Sunnica: Schedule of Changes to Framework CTMP and Travel Plan.

SUNNICA EAST SITE B,
SITE ACCESS I (SE-I)
NEWMARKET ROAD

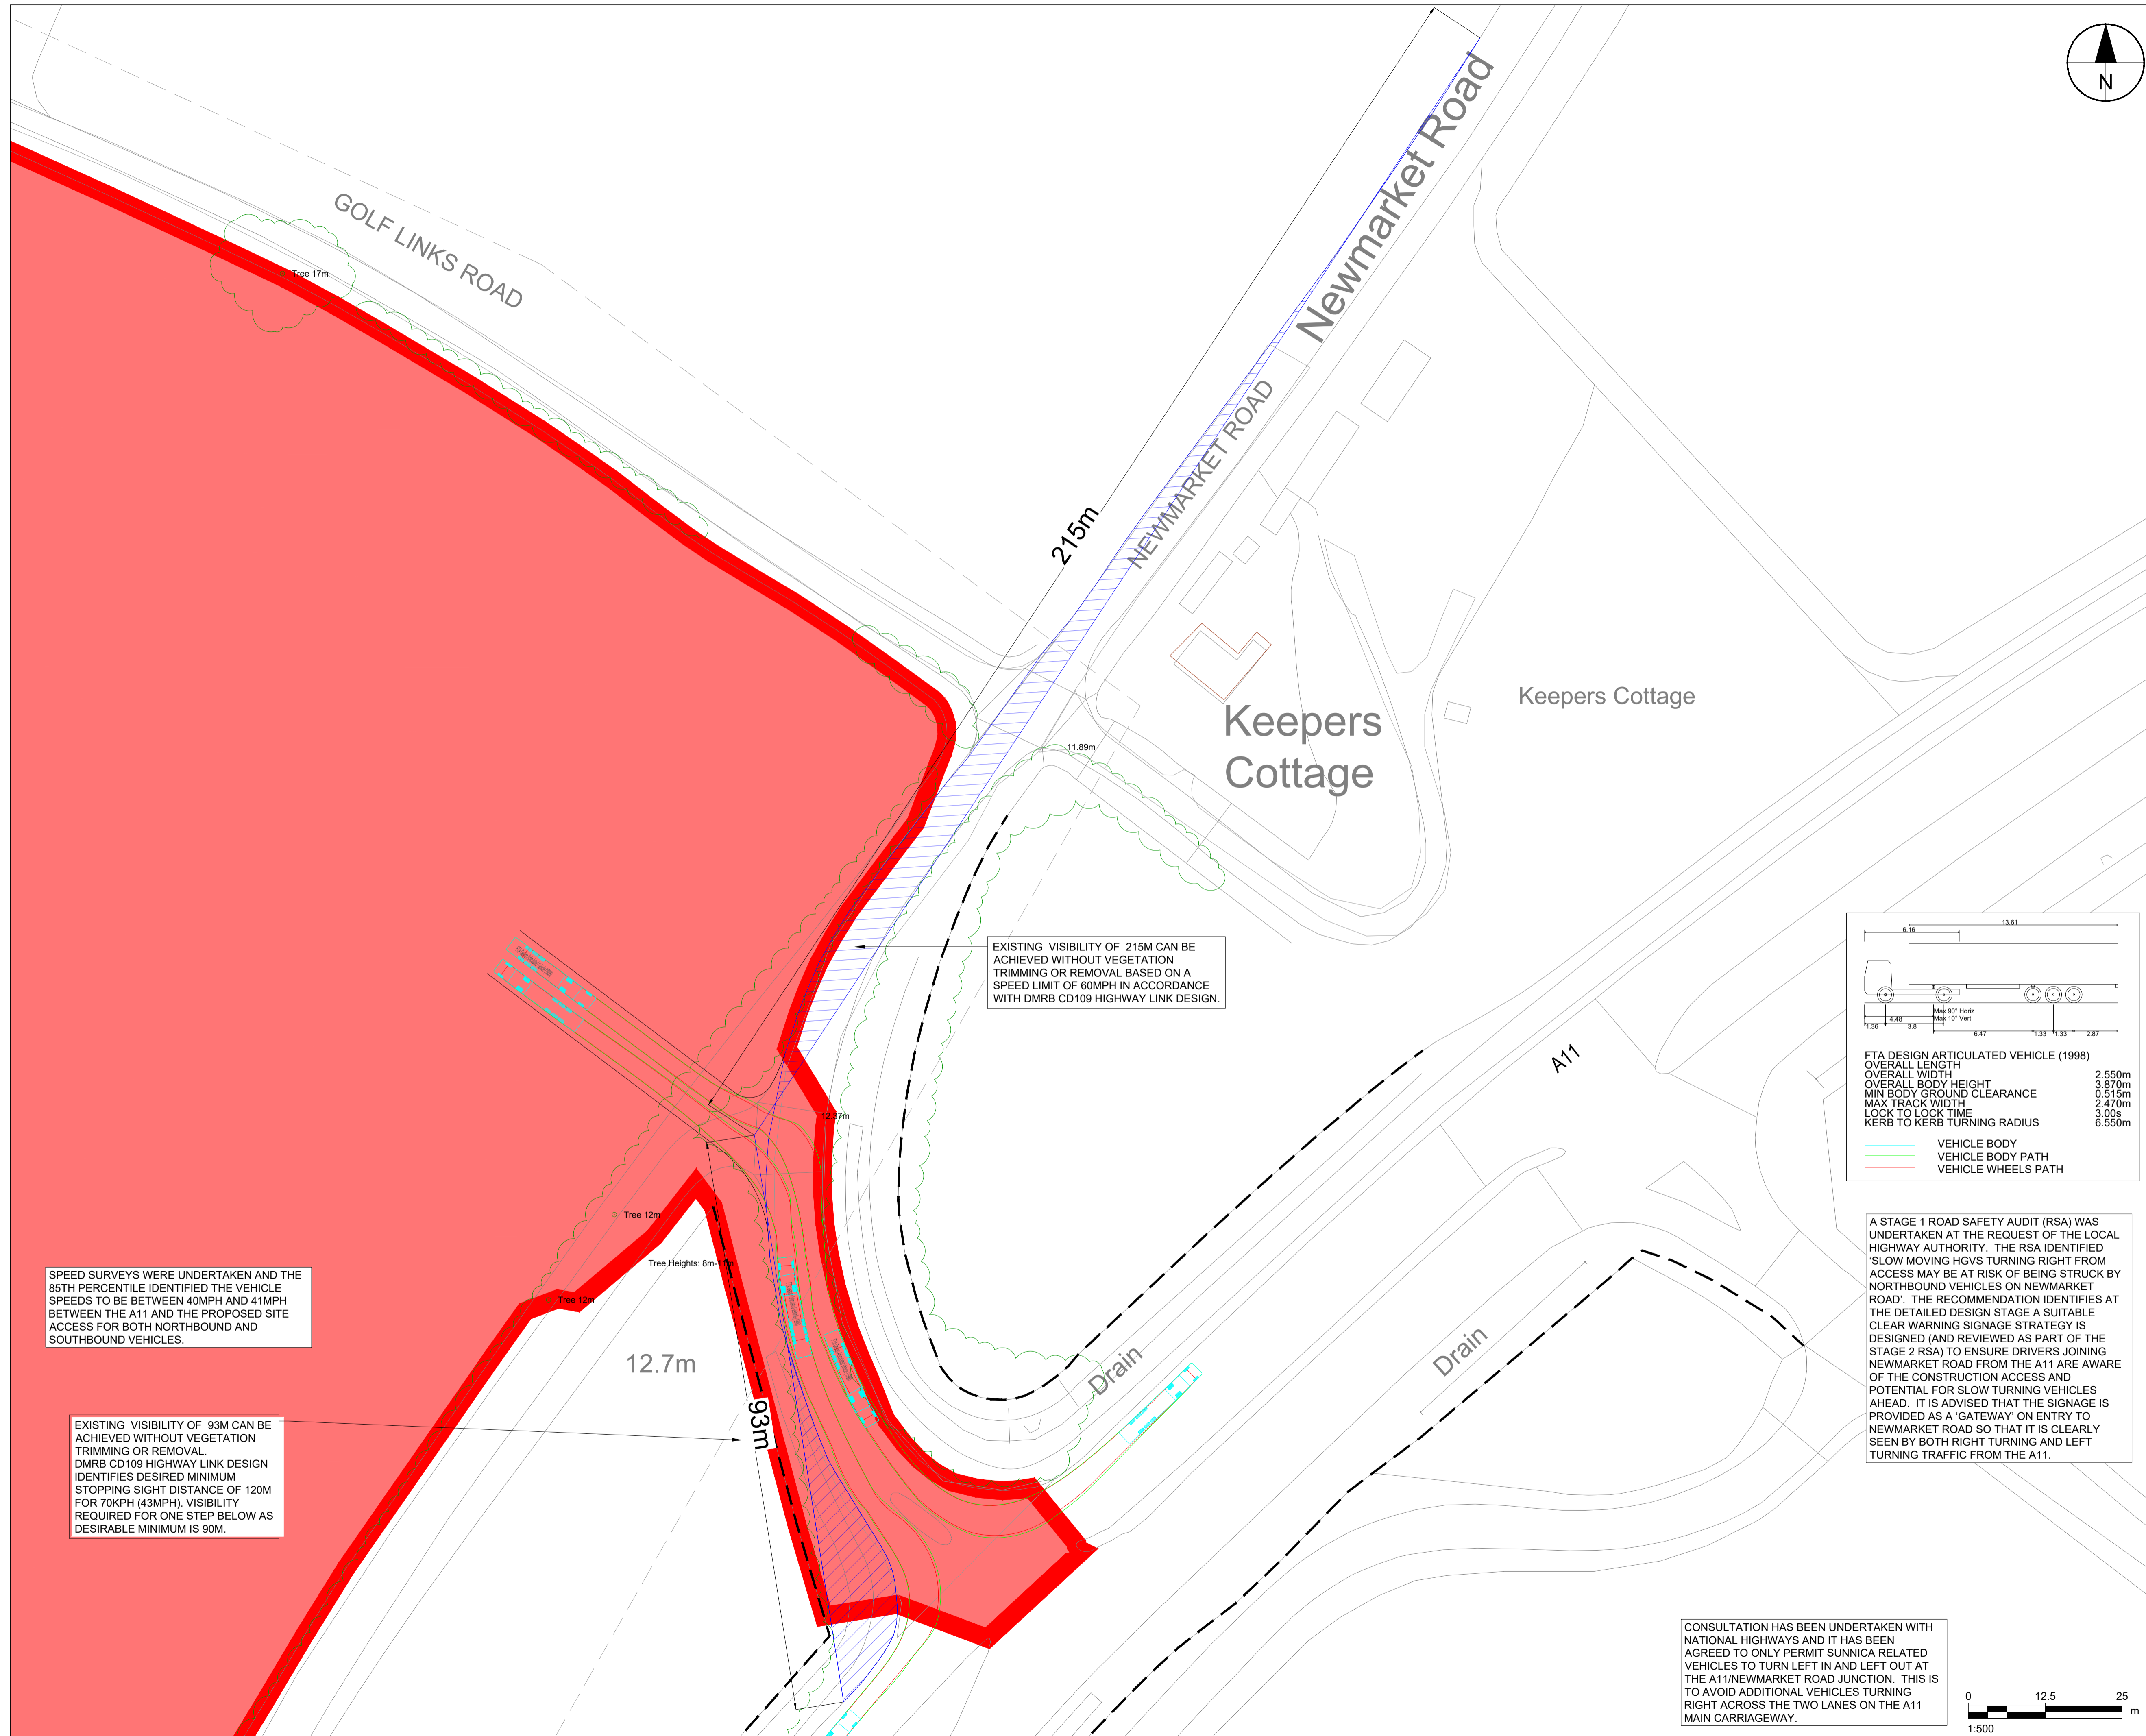
| Ref | Issue | Change |
|-----|--|--|
| 05 | Concerns regarding the signage strategy to be provided at the Newmarket Road site access (between Golf Links Road and A11) | Details of the signage strategy to be provided at the A11/Newmarket Road junction and along Newmarket Road. |
| 07 | Concerns regarding the visibility at the Newmarket Road site access (between Golf Links Road and A11) | The Applicant has commissioned a speed survey closer to the A11 junction, which will be closer to the extent of the visibility splay. |

SUNNICA WEST SITE A,
 SITE ACCESS A (SW-A)
 LA HOGUE ROAD (2 OF 3)

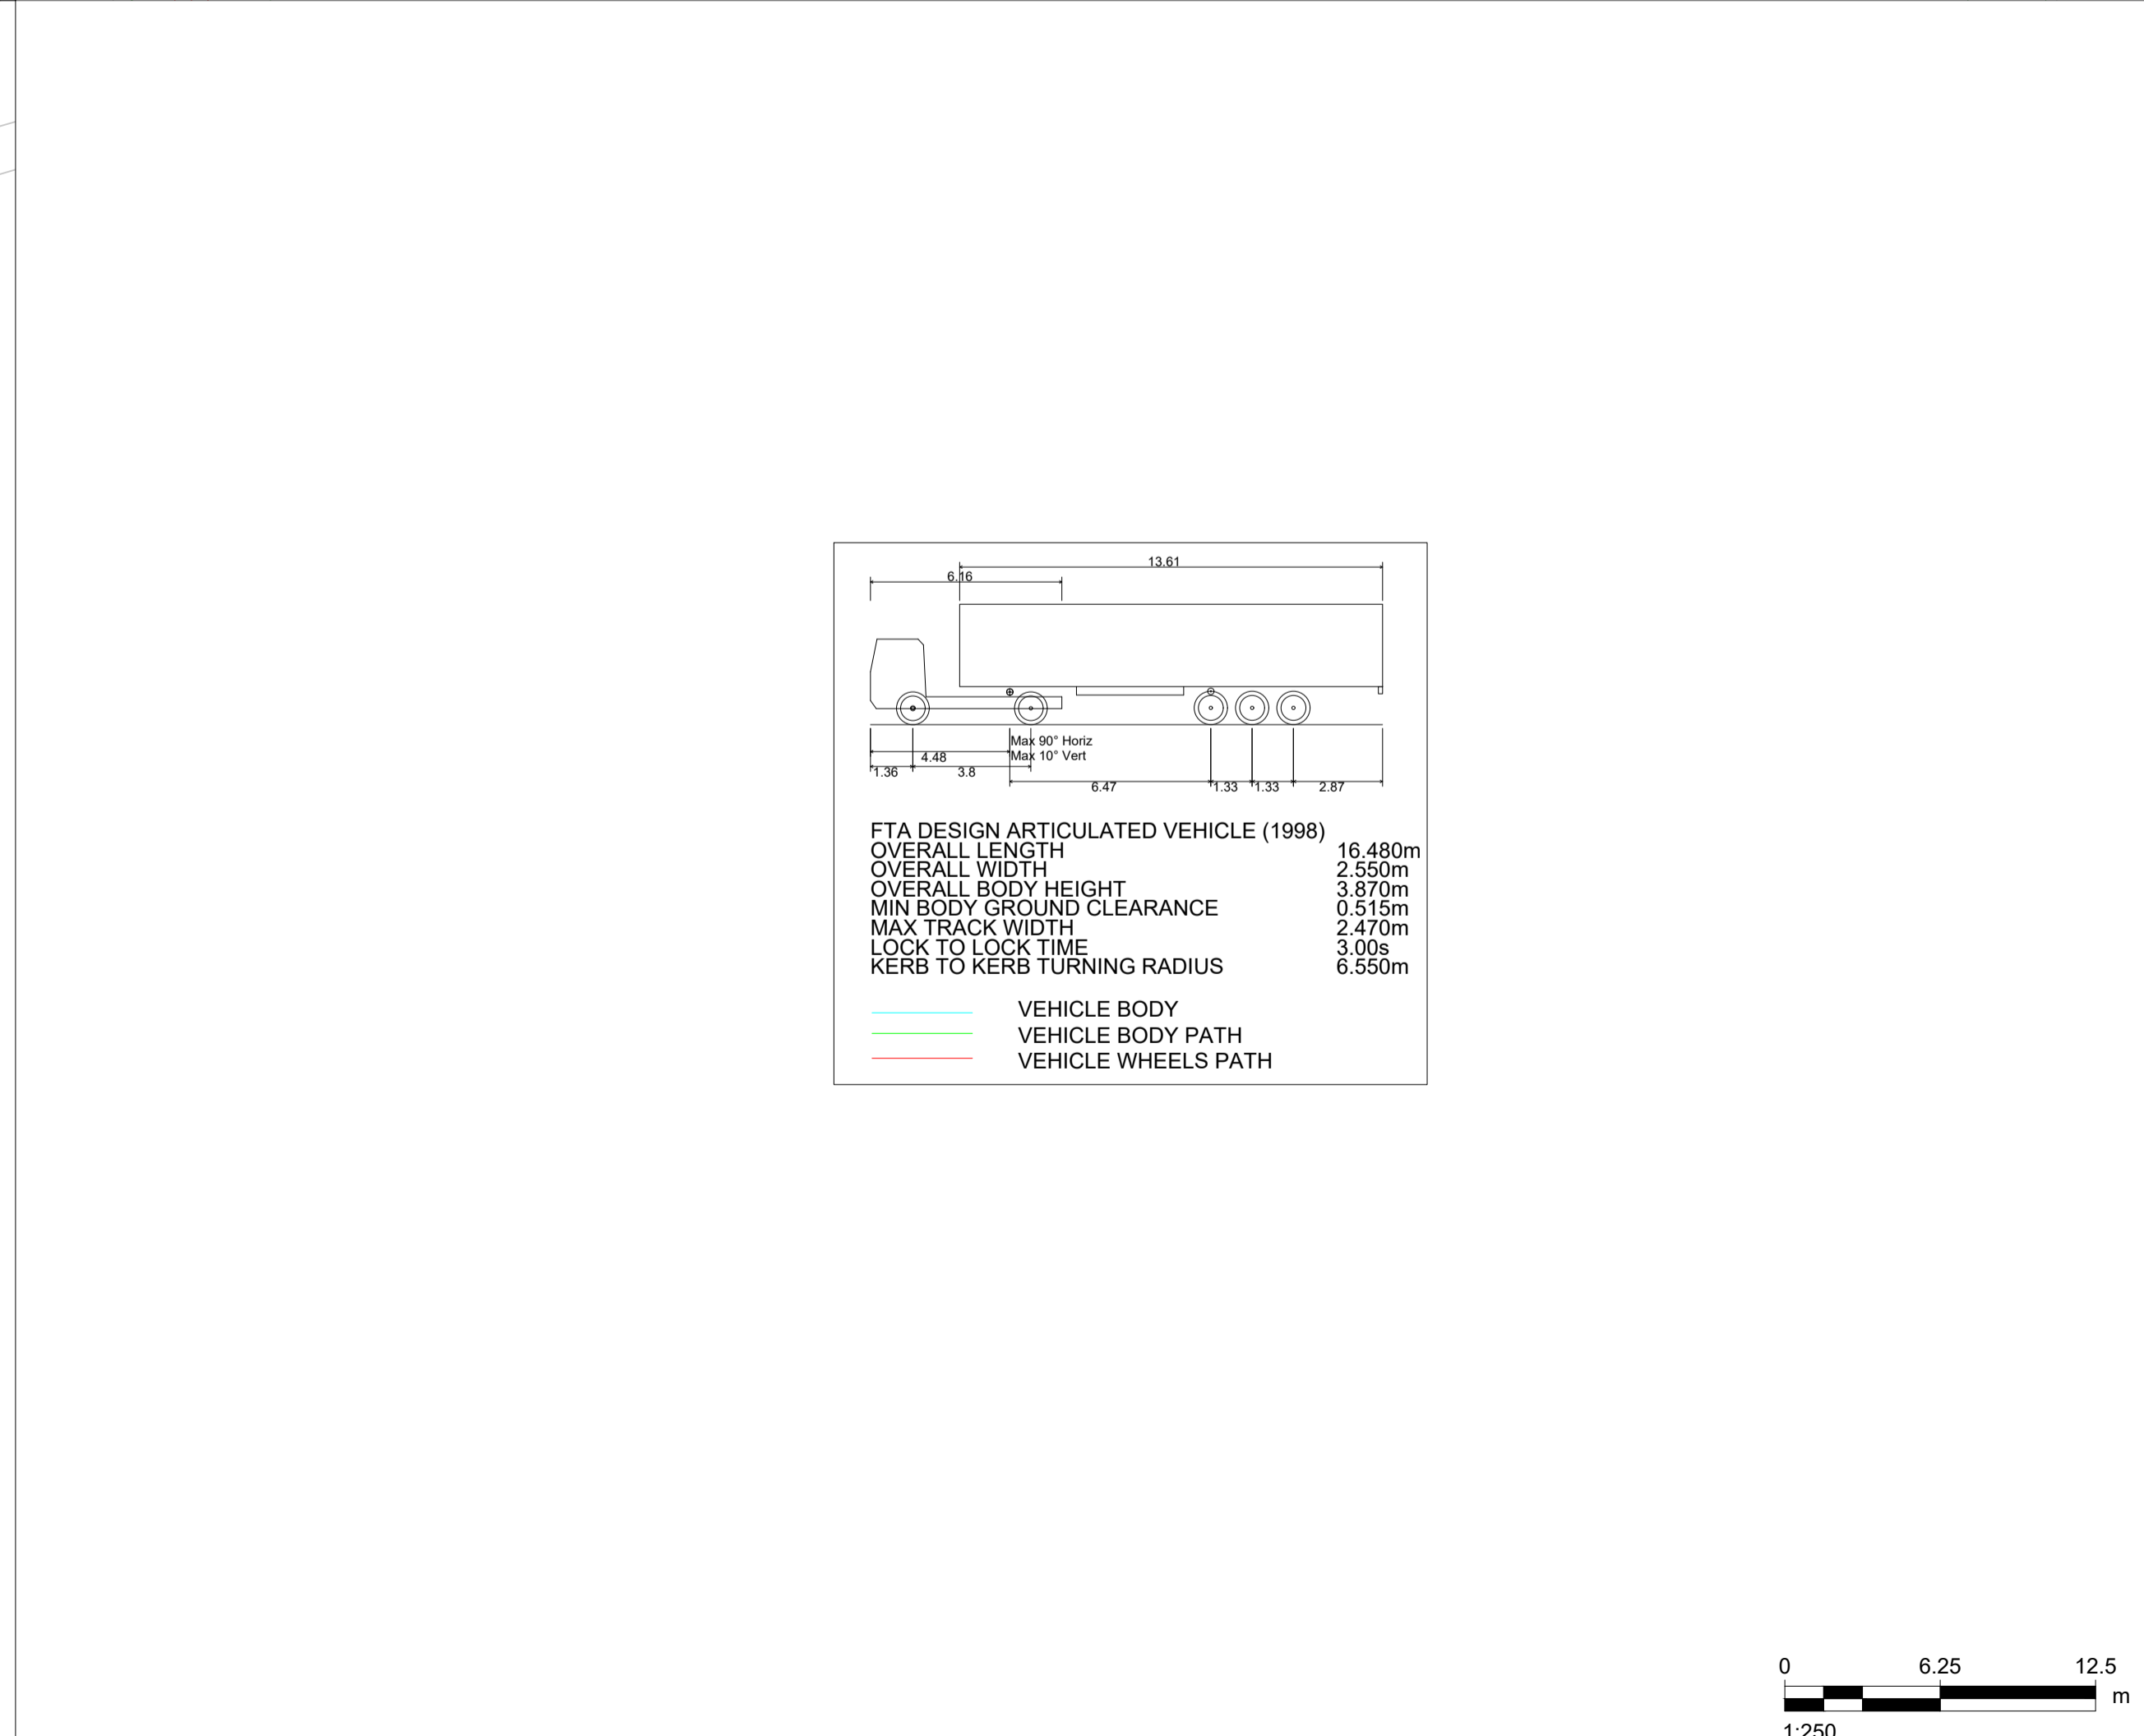
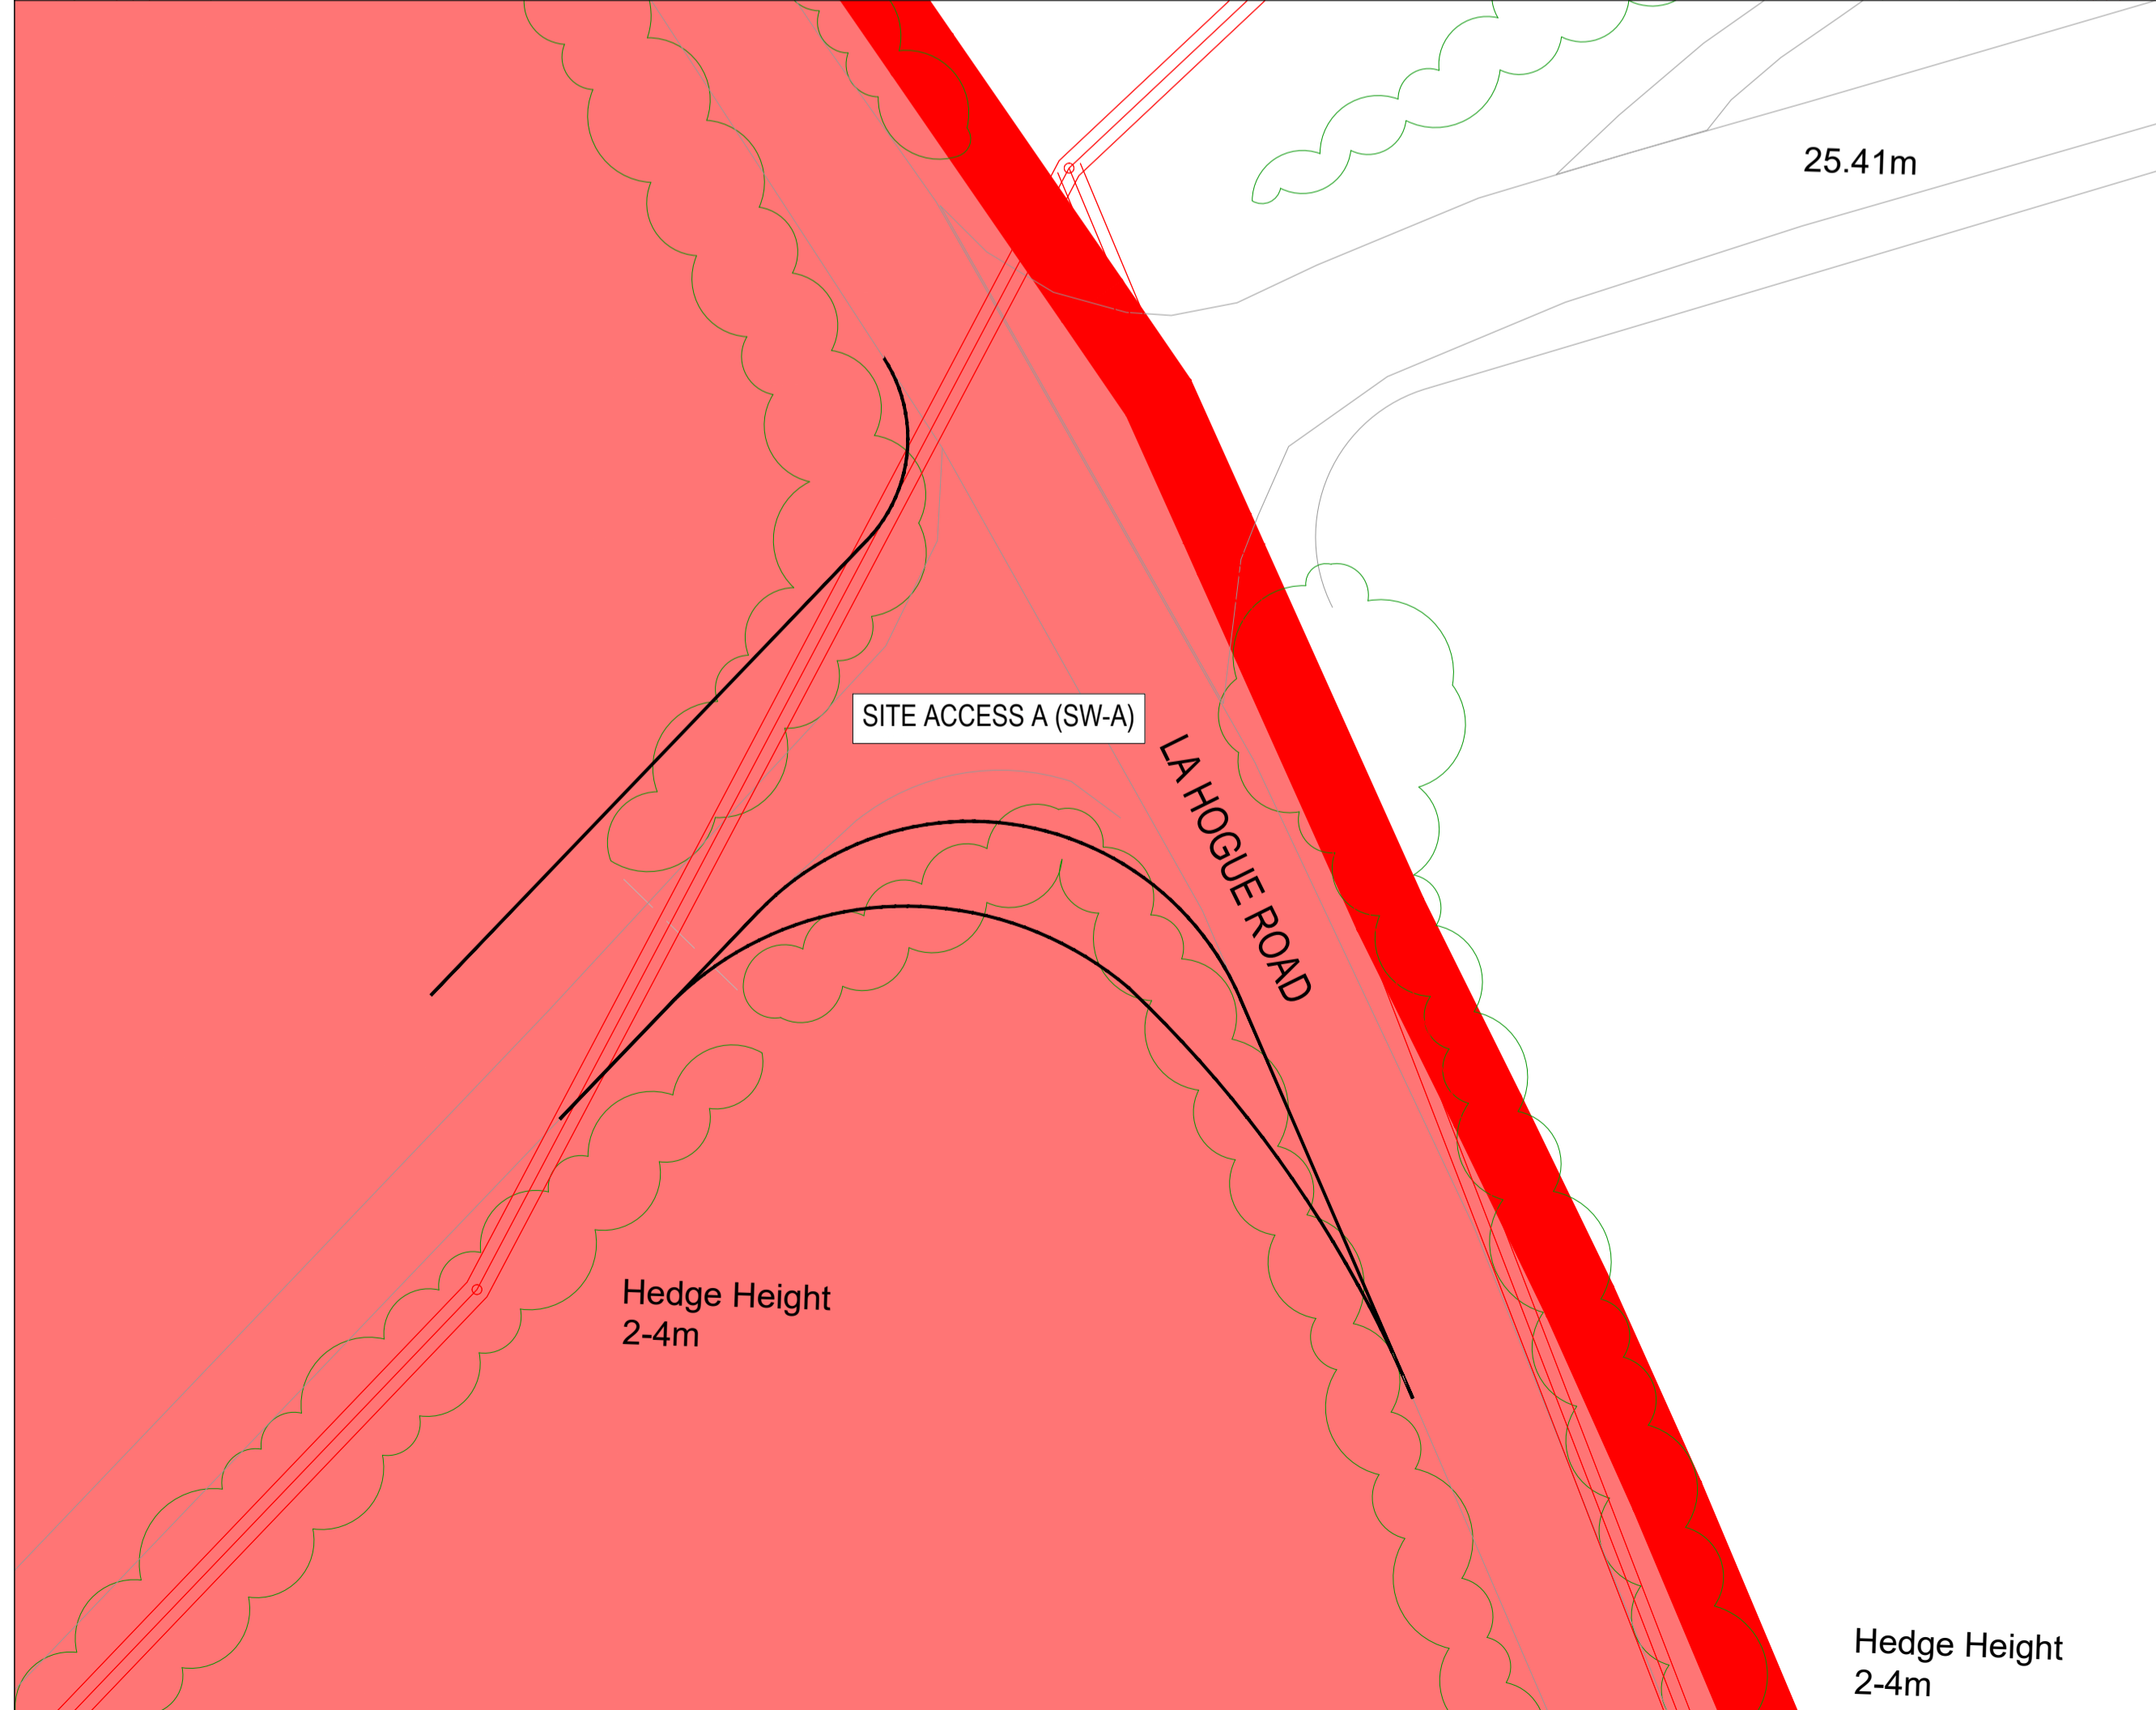
| Ref | Issue | Change |
|-----|--|--|
| 10 | Clarification regarding the site access layout during the construction and operational phase at the Sunnica West Site A: Site Access A on La Hogue Road. | <p>The Applicant will:</p> <ul style="list-style-type: none"> Provide clarification on the swept path analysis, visibility splay and the site layout during the construction phase Strengthen control measures set out in the CTMP and Travel Plan. |

| | | <ul style="list-style-type: none"> • Provided clarification on the swept path analysis, visibility splay and the site layout during the operational phase. |
